### INTAKE SCREENING COMMENTS RESPONSE

Permit Number **2208-260**

Project Address 8455 SE 83<sup>RD</sup> ST.  
Mercer Island, WA 98040

Subject **Response to Building Permit Intake Screening Comments**

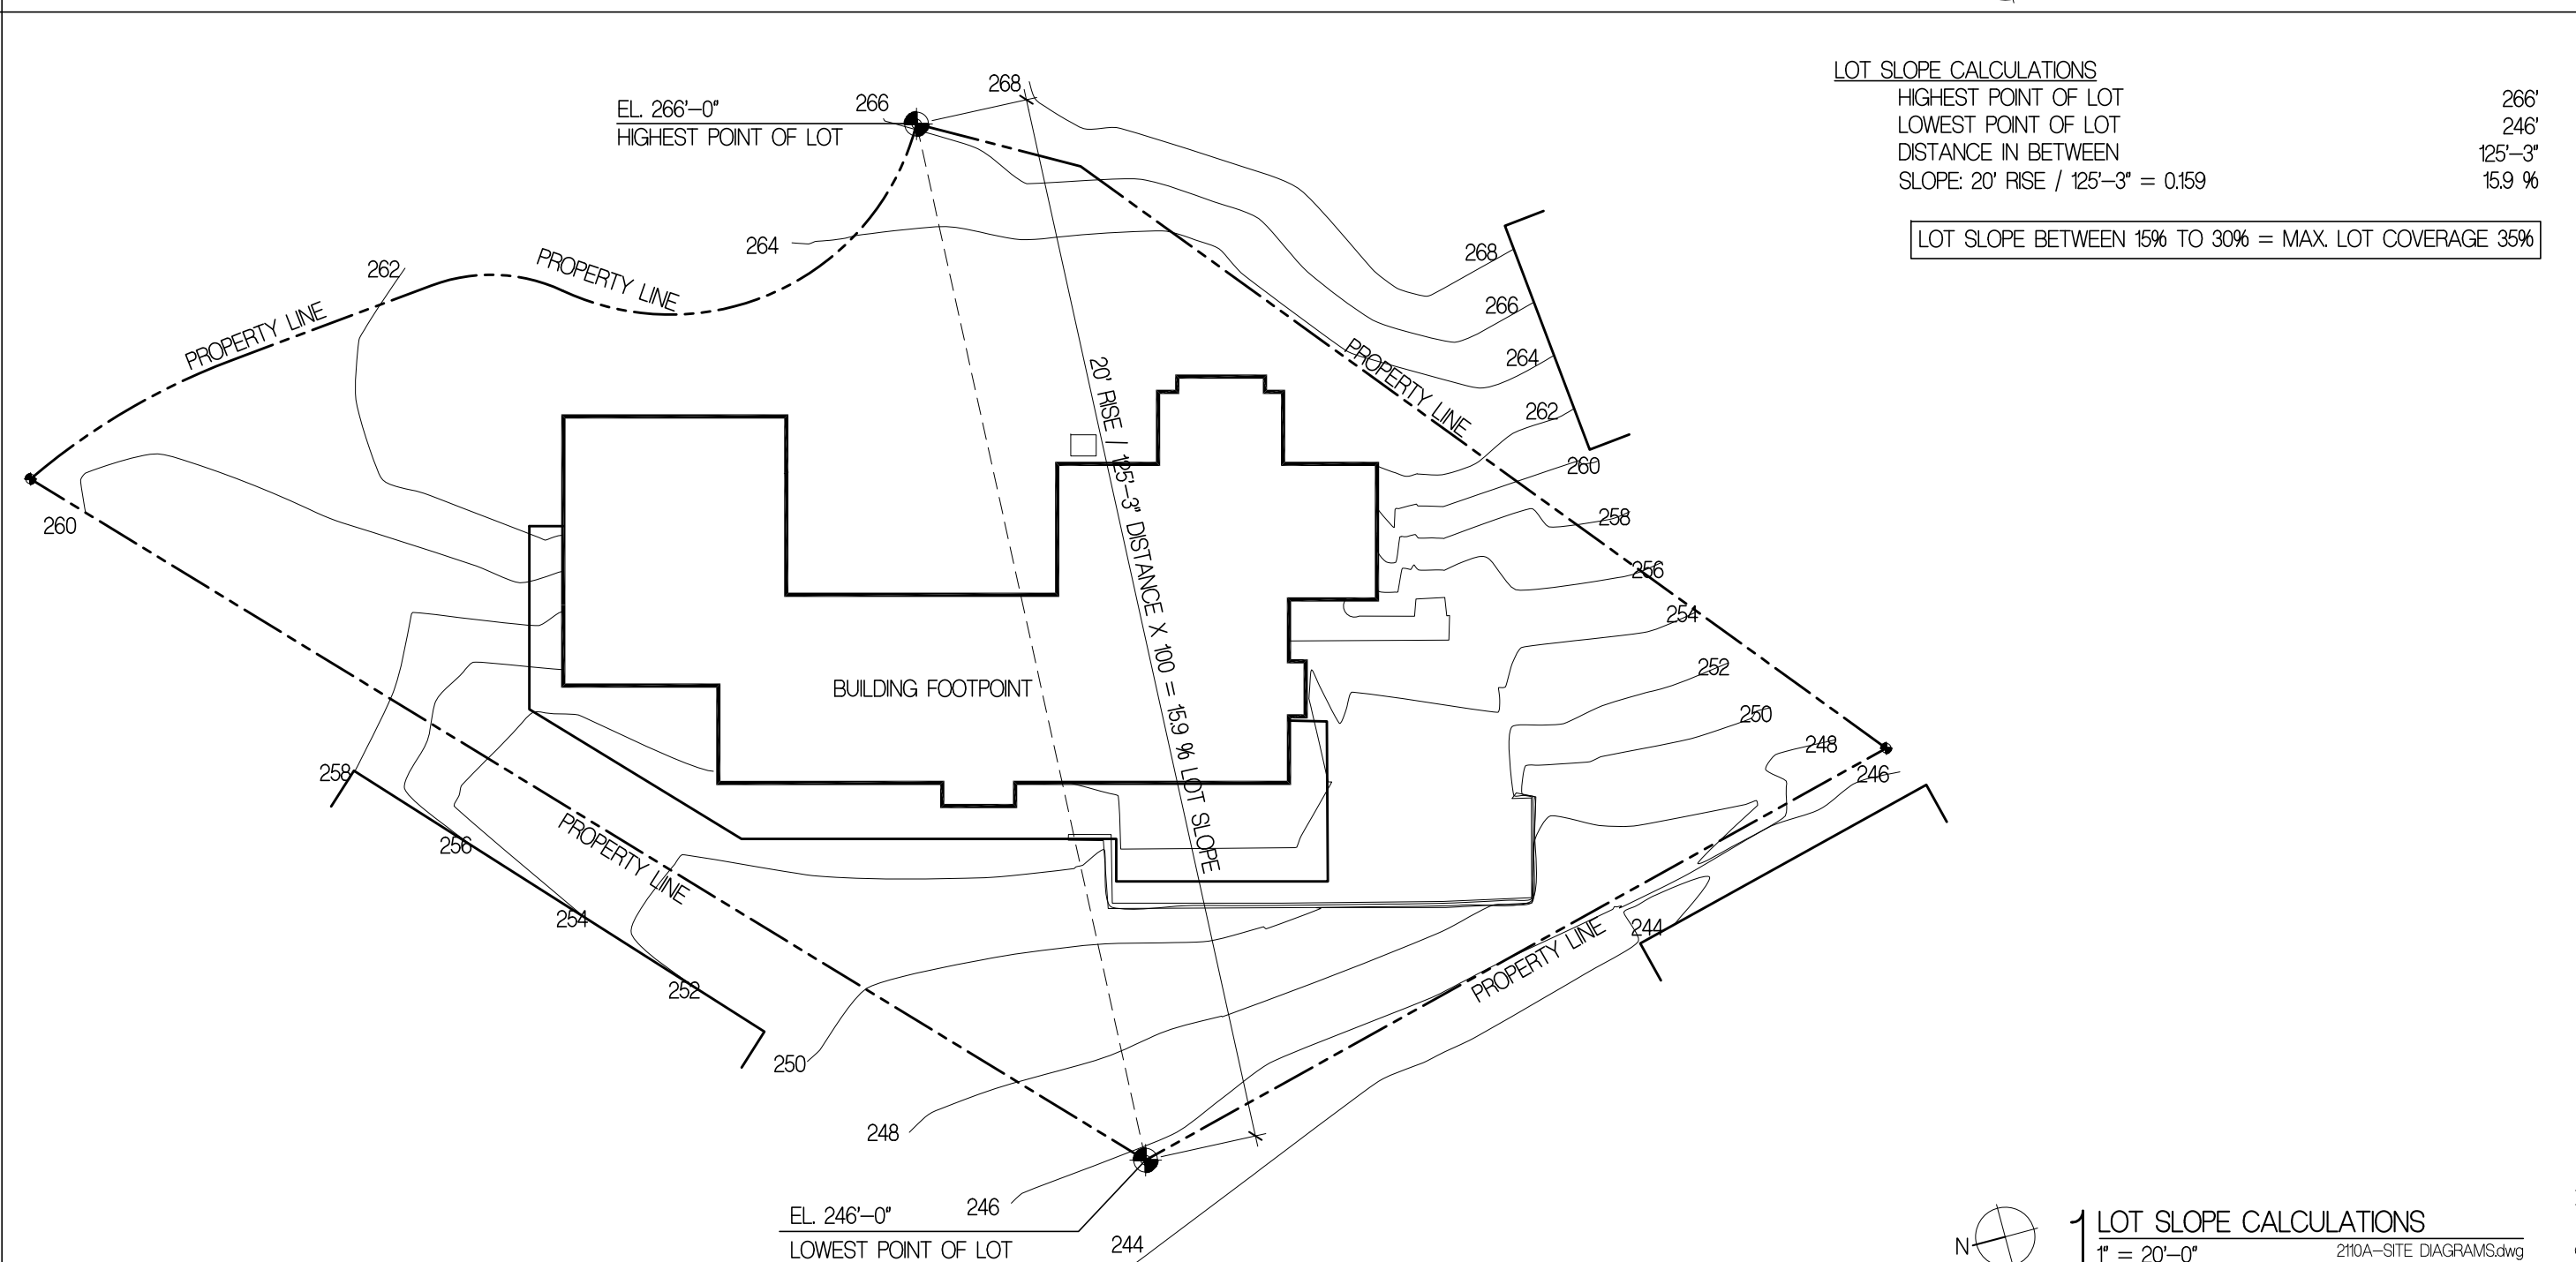
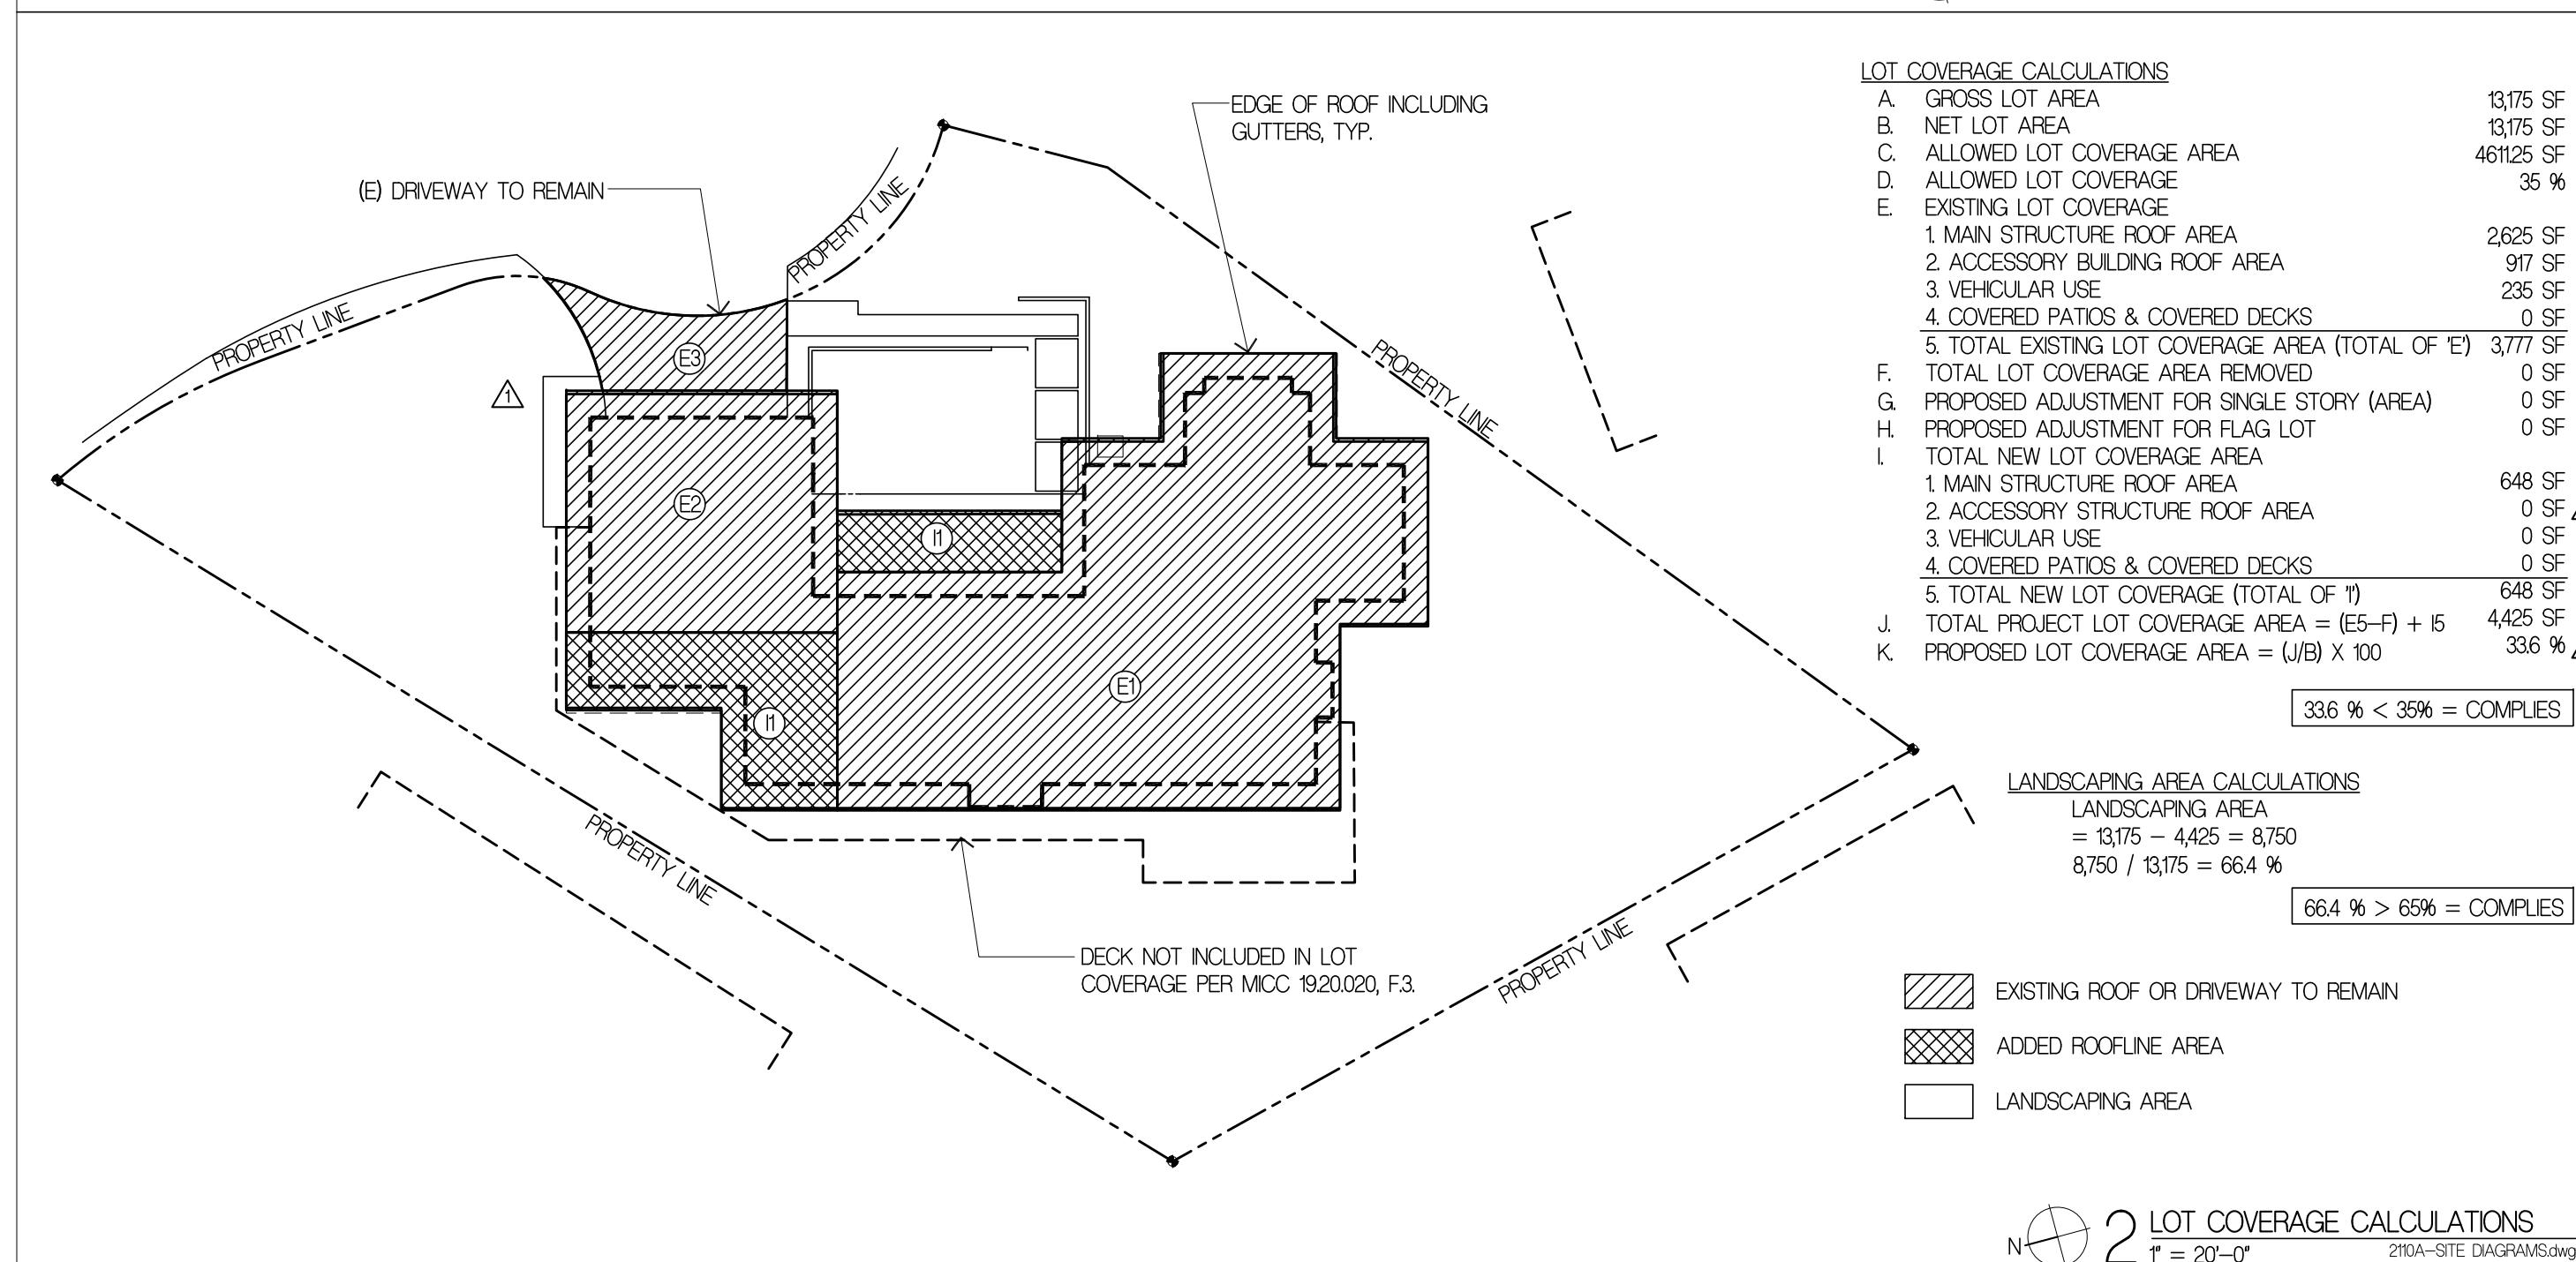
1. **Site Plan:**  
Response: As directed in the comment, Driveway length & widths have been noted on TS-2, Site Plan. The 2 minimum parking spaces required – this has been noted on TS-1 Project Information sheet under 'Zoning Information'.

4. **Critical Area on Plan:**  
Response: The dashed line showing the Critical Area shown on Site Plan sheet TS-2 has been made darker to enhance the visibility. The note is located near the bottom left of the drawing sheet.
